**ADC Planning Consultation
Conservation/Design Officer Response**

Application Number	R/131/17/PL
Address	Land Adjacent Abbots Lodge 85 The Street Rustington BN16 3NL
Description	6 No. one bed apartments. This application affects the character & appearance of the Rustington Conservation Area and a Listed Building.
Case Officer	Mr D Easton
Date	31.10.17

SITE PLAN SCALE 1:200 @ A3

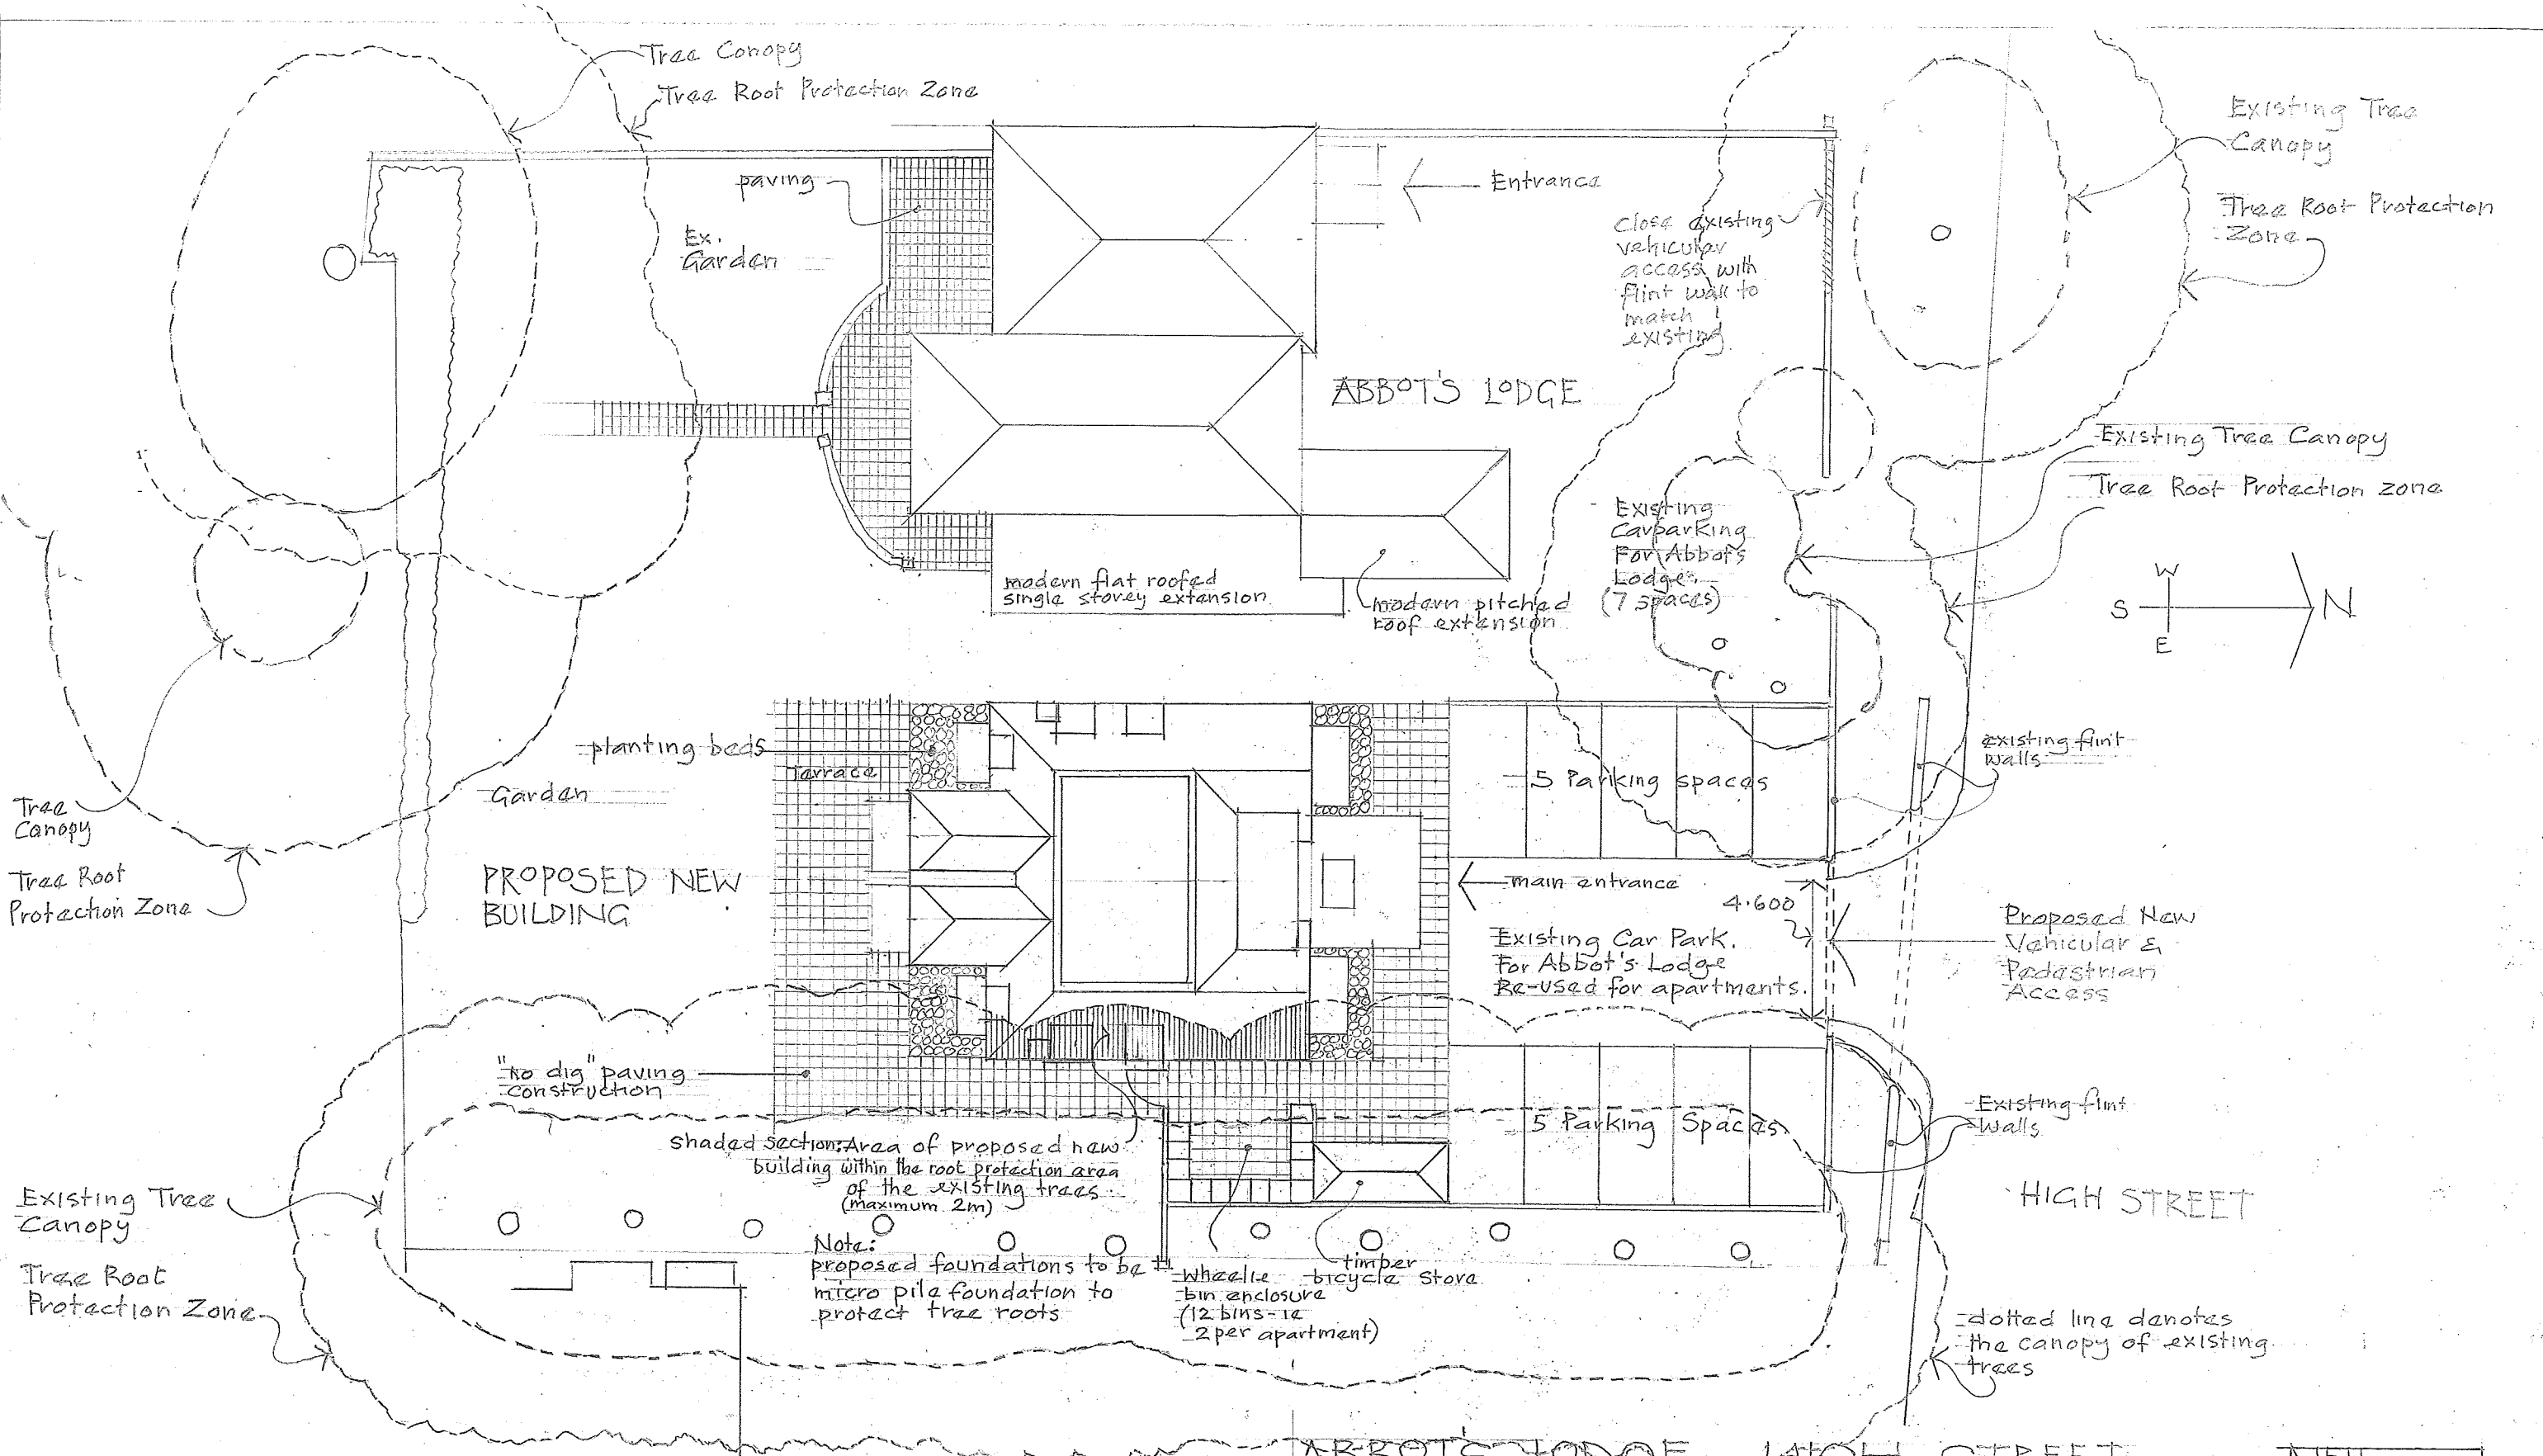
It is considered that the proposal would compromise the special character of the Conservation Area as overly dominant in terms of its massing and siting within the plot. The proposal would also be highly visible looking into the Conservation Area from The Grangeway, Claigmar Road and looking East along The Street.

NORTH ELEVATION [Proposed Apartments]

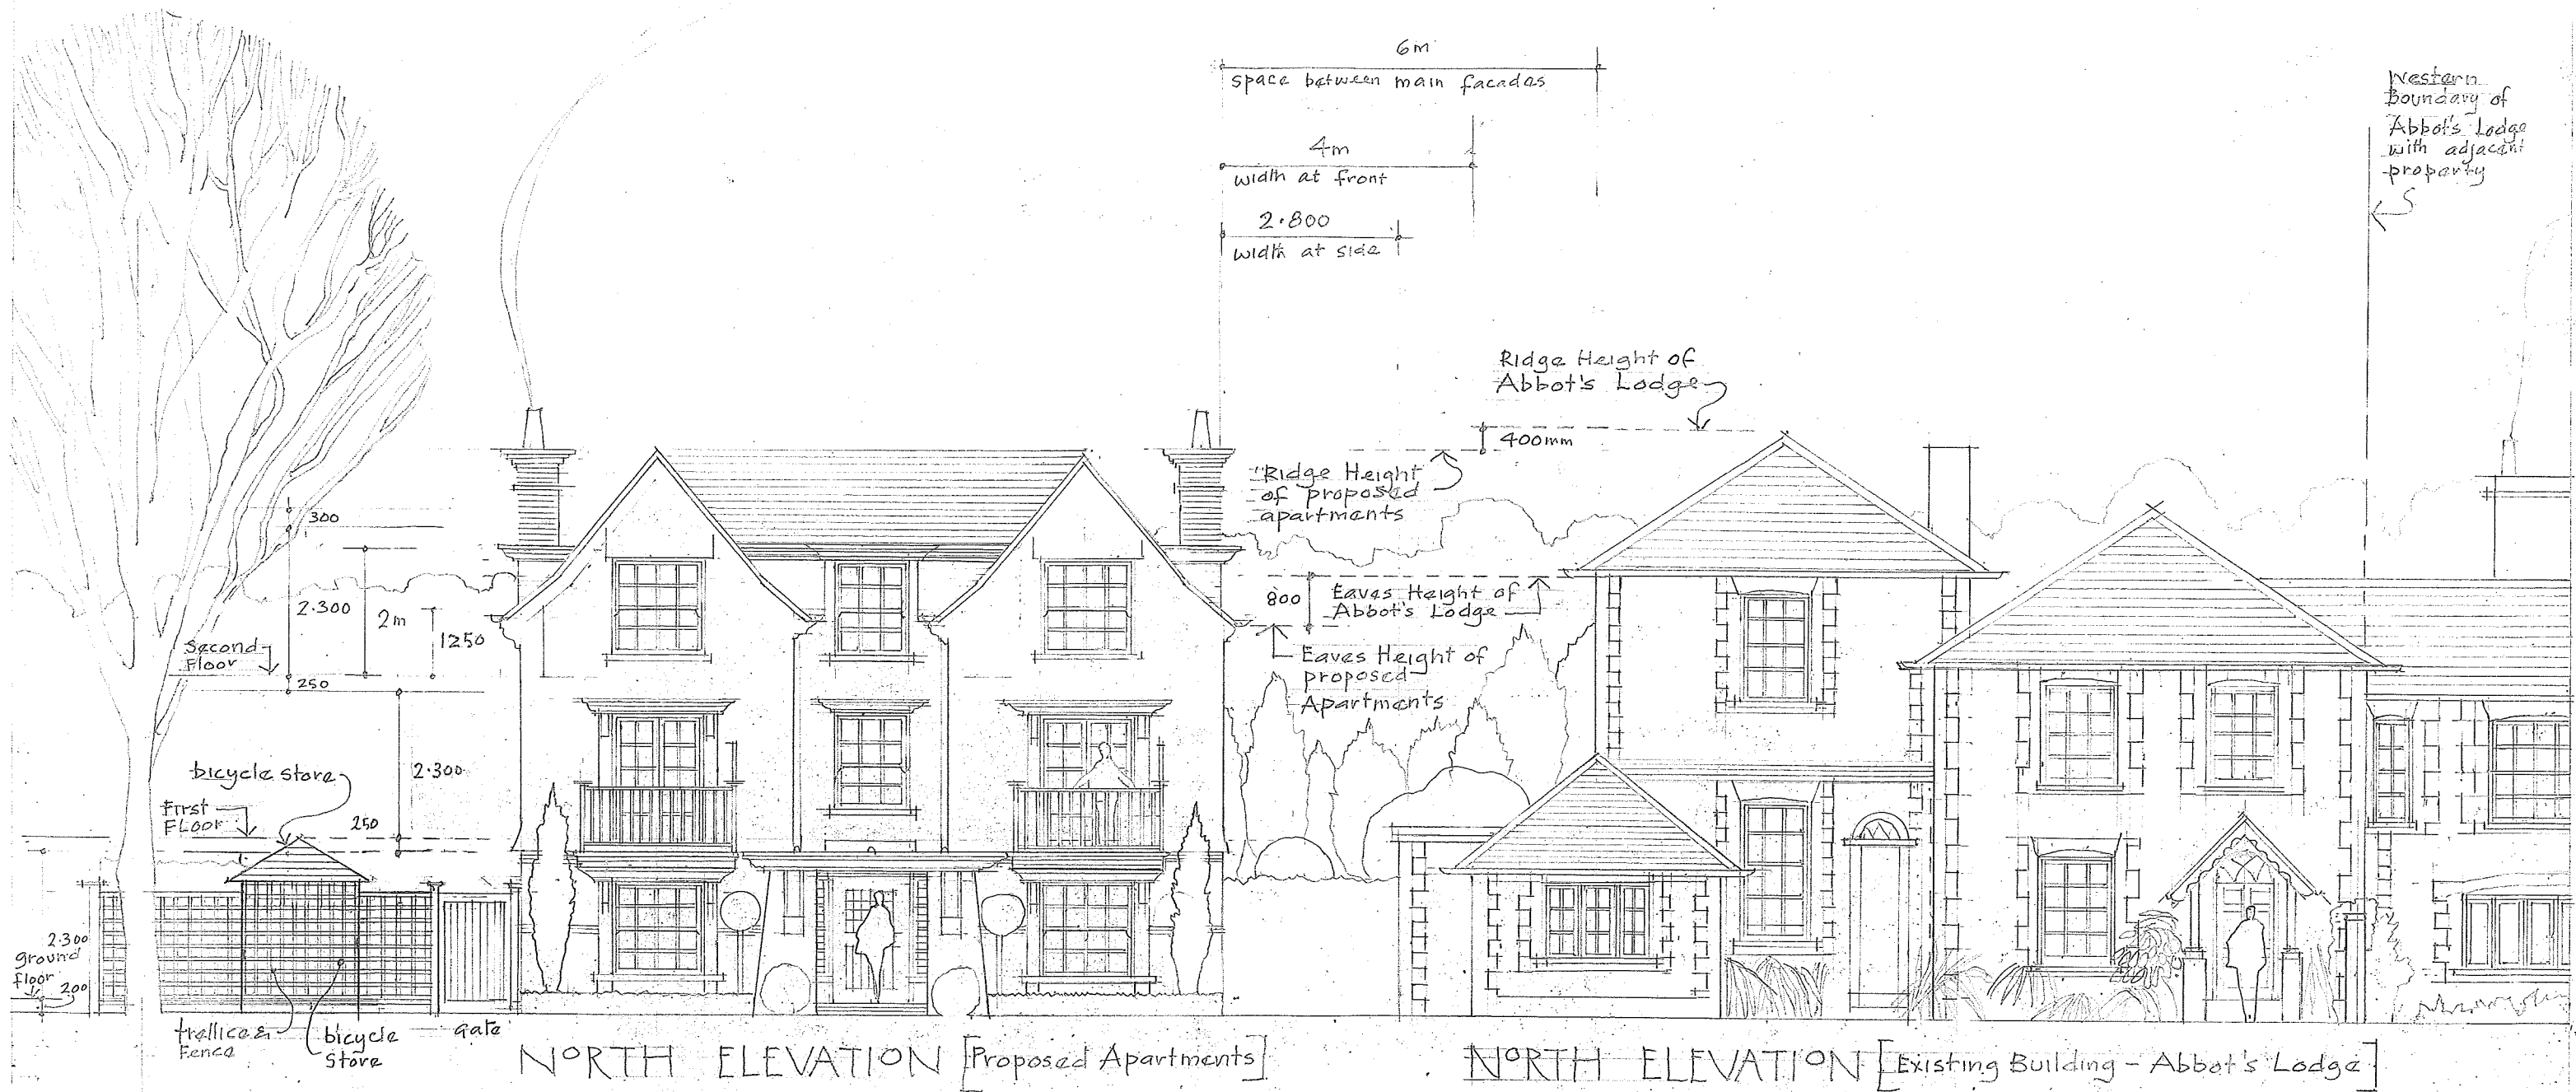
The relationship of the proposal with the listed Abbots Lodge is uncomfortable and is considered visually dominant in relation to the heritage asset, its setting and that of the Conservation Area. The proposal is of three storeys, which is more than is

typical of the area, with rendered finish and general detailing - including white metal balconies - is considered both out of character with the surroundings, and fails to make a positive contribution to it. In addition to the building itself, the application notes the breaching of the historic flint wall to make new vehicular and pedestrian access; the creation of 10no. parking spaces to the front of the plot; and the erection of a street-facing timber cycle/bin store. It is considered that the hard landscaping, lighting and proposed paving surround the proposed building would be detrimental to the setting of the listed building and the character of the Conservation Area.
